**From:** [Holly Erdman](#)  
**To:** [Dusty Pilkington](#); [Tristen Lamb](#)  
**Subject:** RE: LP-17-00007 Swauk Valley Ranch Revised Application  
**Date:** Thursday, February 08, 2018 4:56:13 PM

Survey For  
**SWAUK VALLEY RANCH, LLC.**  
Sections 17, 20, T. 19 N, R. 17 E, W.M.  
Kittitas County, Washington

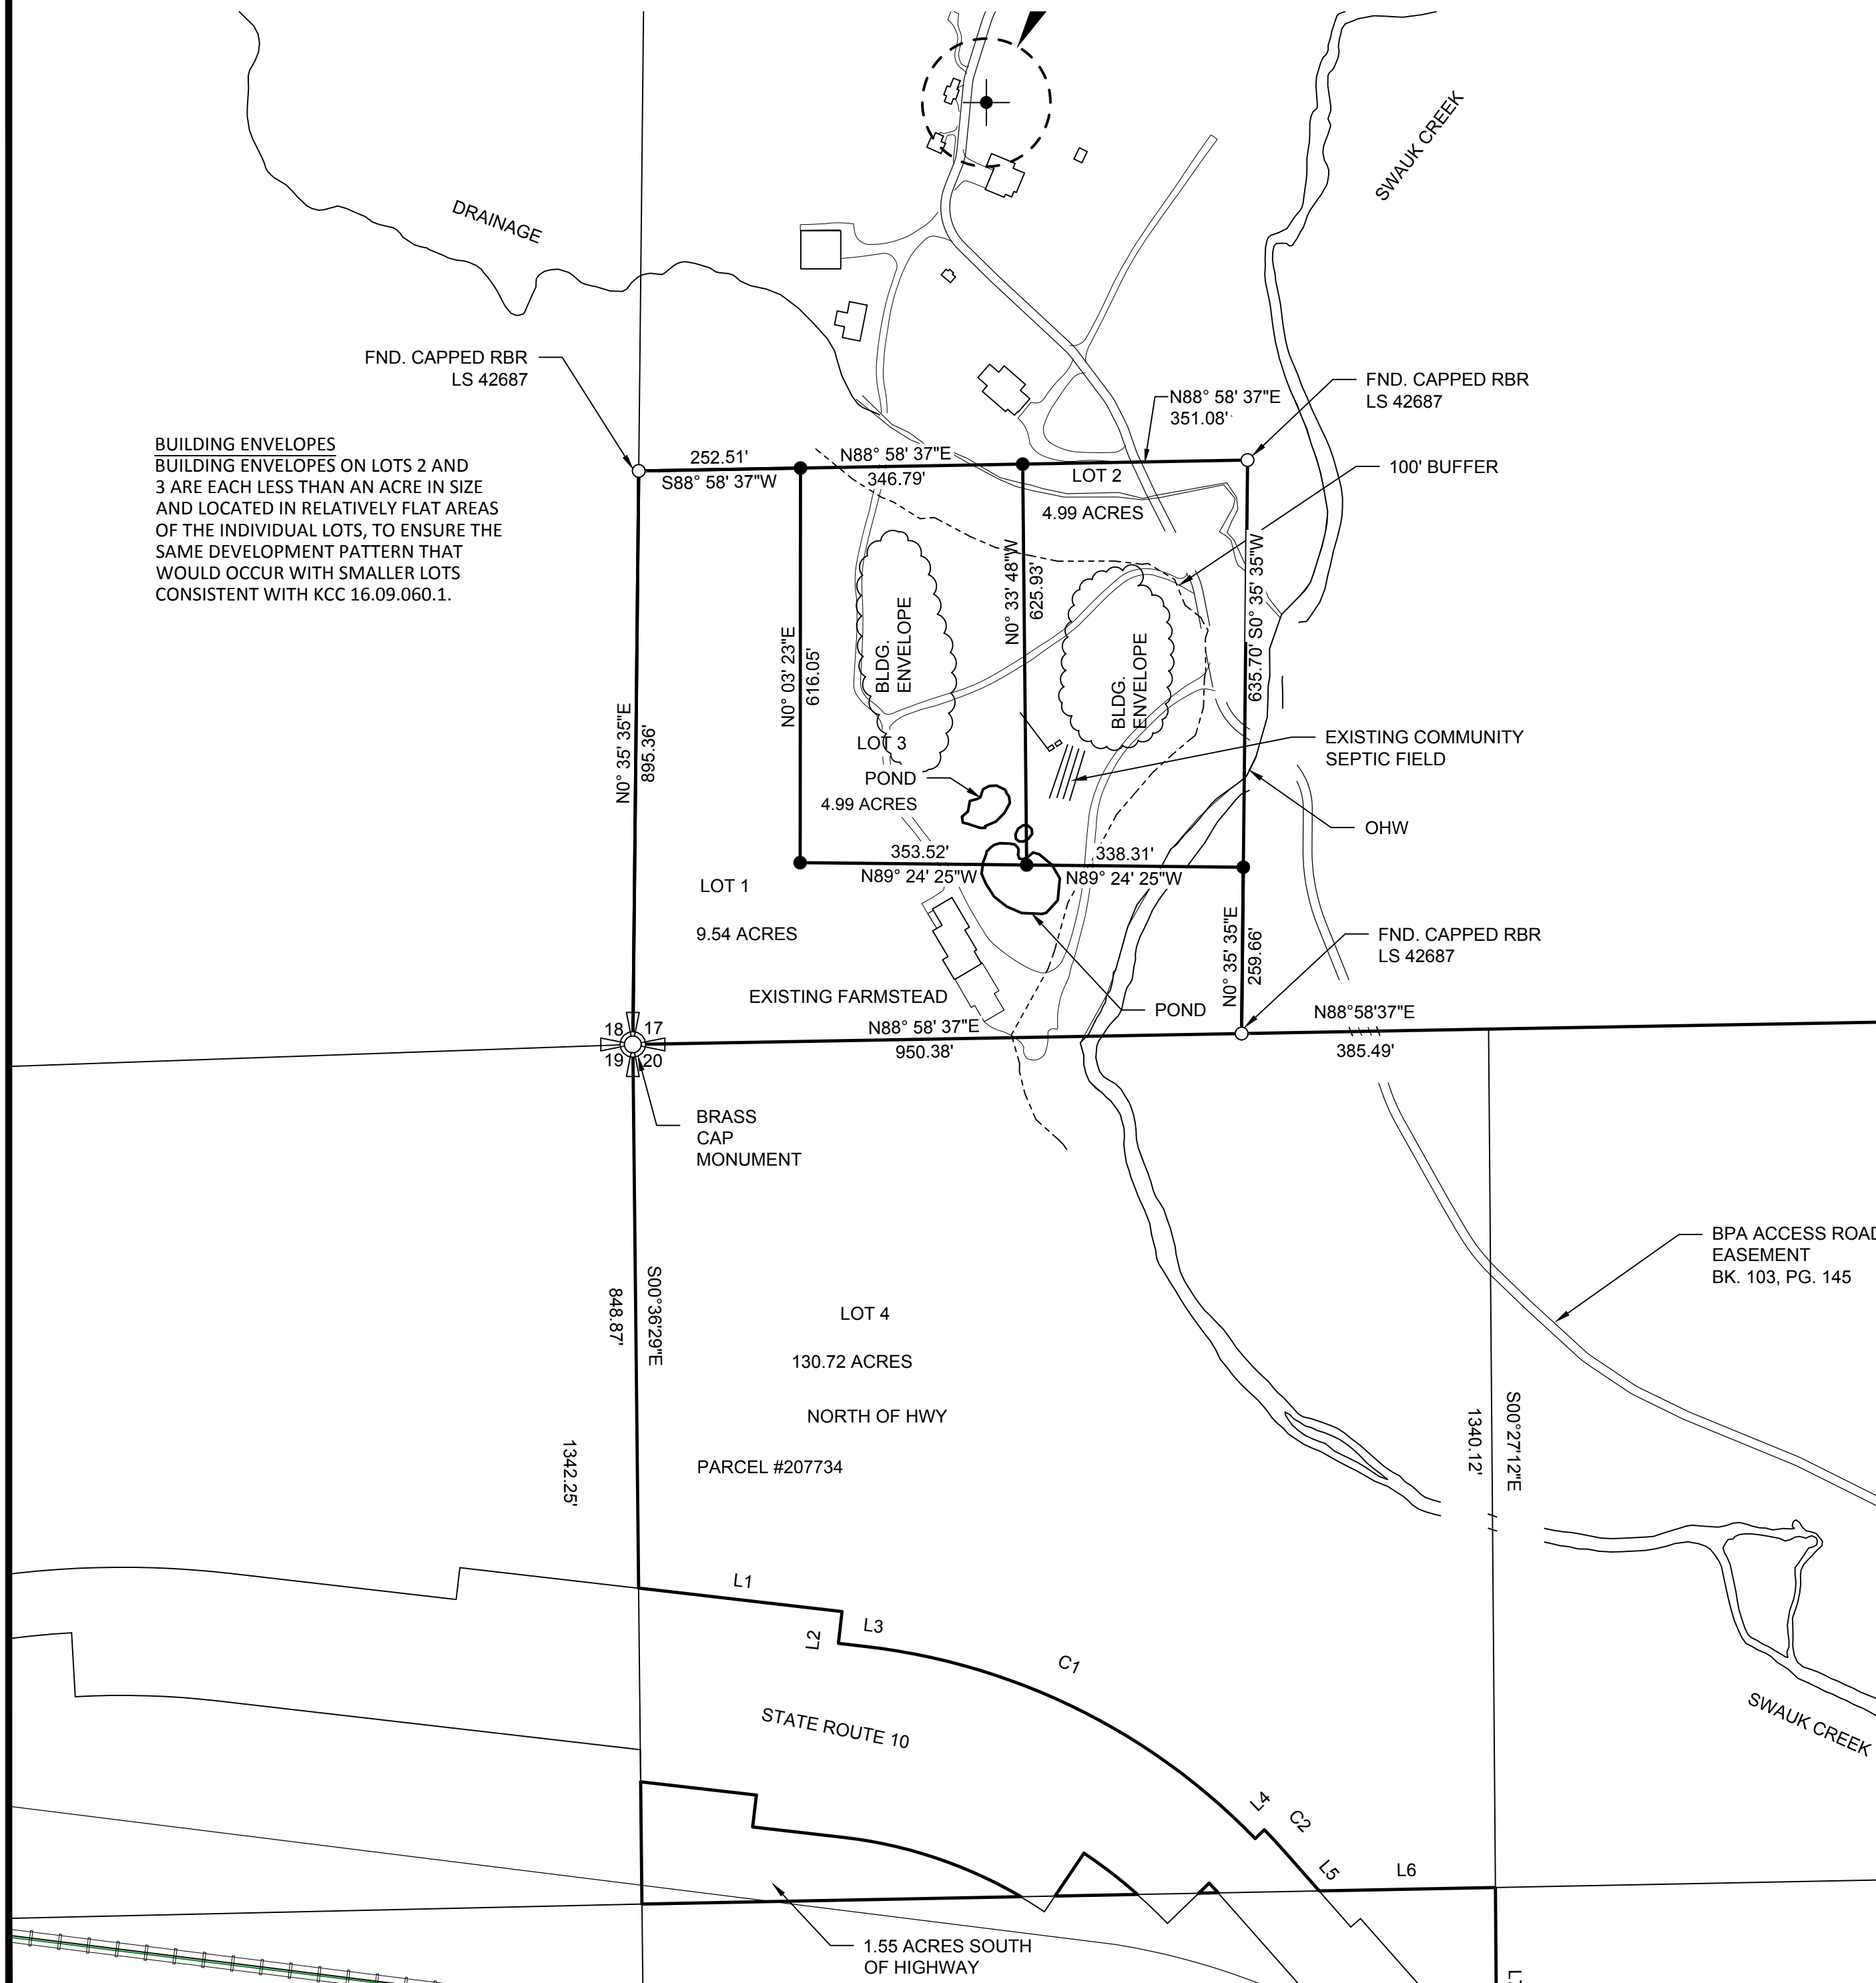
- 1) A current bacteriological test.
- 2) A current nitrate test.
- 3) The signed SMA (Satellite Management Agency) contract they have with Evergreen Valley Utilities.
